Wise Engineering
3915 Old Fairground Rd.
Angier, NC 27501
(919)894-2203

June 28, 2021

Subject: 2077 Bunnlevel Erwin Rd, Bunnlevel, NC 28323

A representative from Wise Engineering (WE) reviewed the existing footing excavations at 2077 Bunnlevel Erwin Rd, Bunnlevel, NC to test the bearing capacity of the soil within the test pits.

**FOUNDATION PLAN
 1ST FLOOR FRAMING**

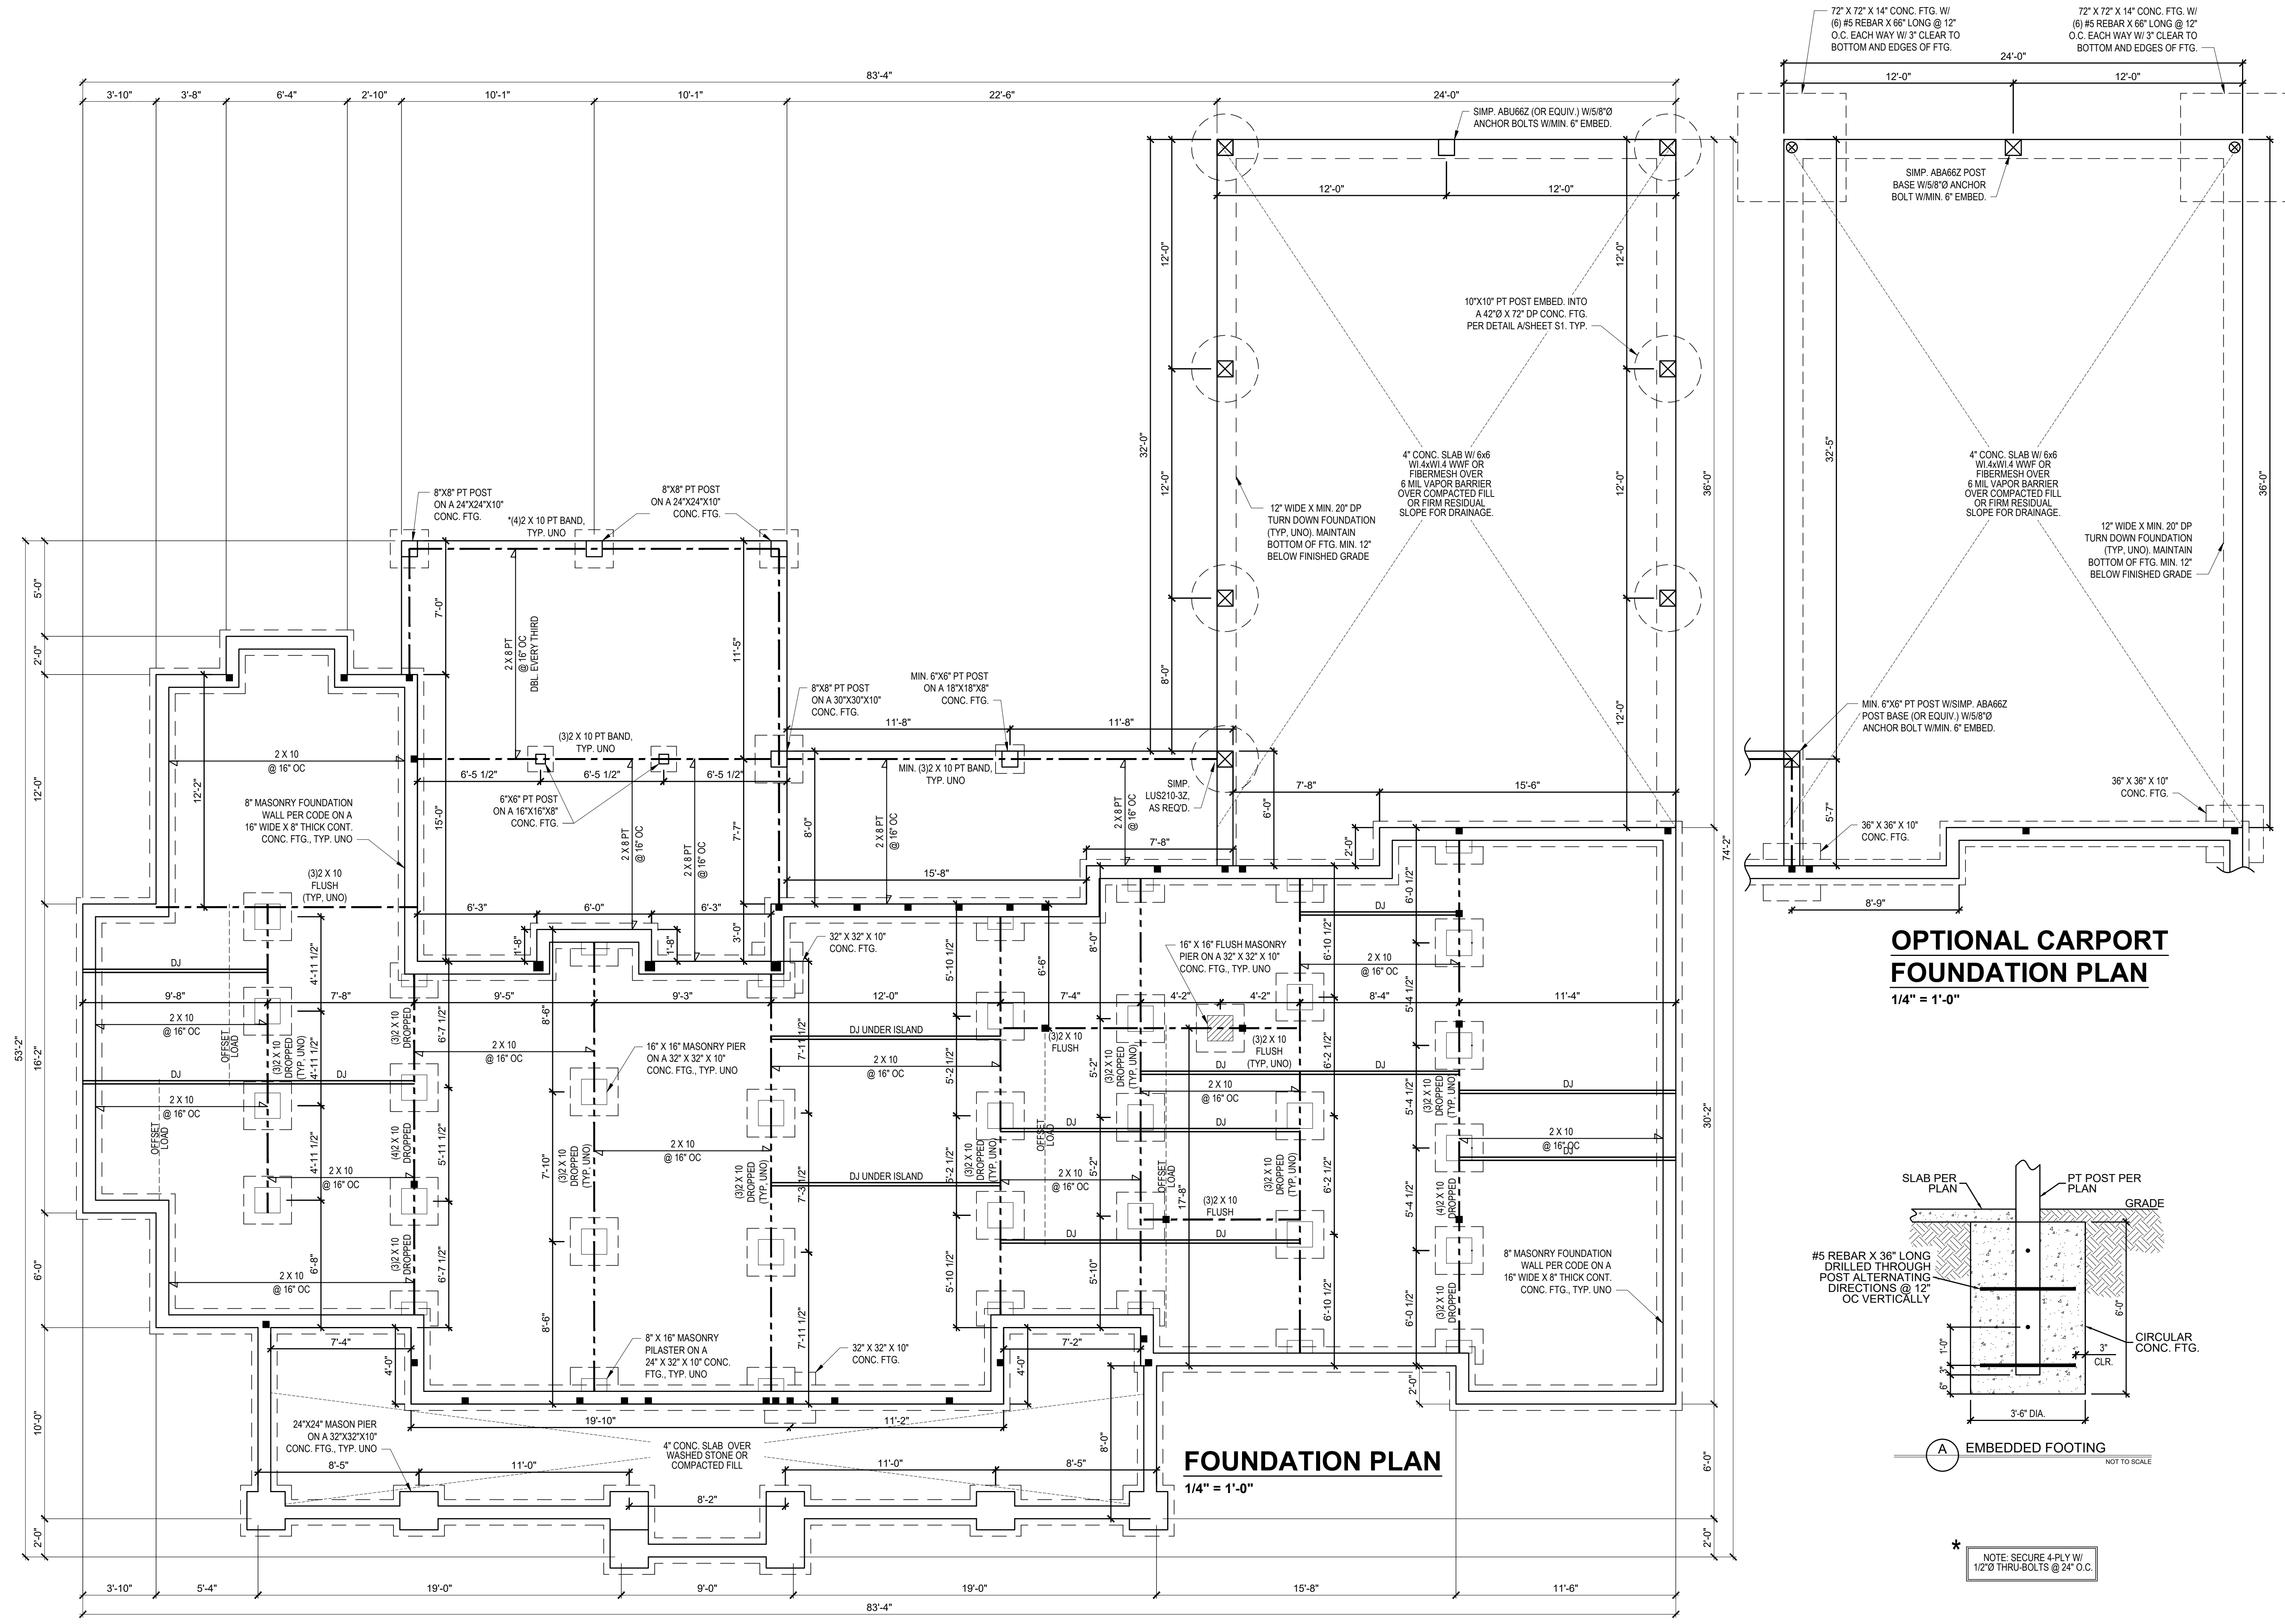
Based on our analysis, the soil within the test pits at the plan specified footing elevation is structurally deficient. WE recommends over-excavating the footing by 3'-0" or until the soil is able to support a minimum of 2000PSF bearing capacity. The over excavated footings should be backfilled with clean washed stone (#57) back to the plan specified footing elevation. Provided the footing enhancements are properly implemented, the soil within the footing excavations is structurally adequate to support the anticipated loading conditions (2000PSF bearing capacity).
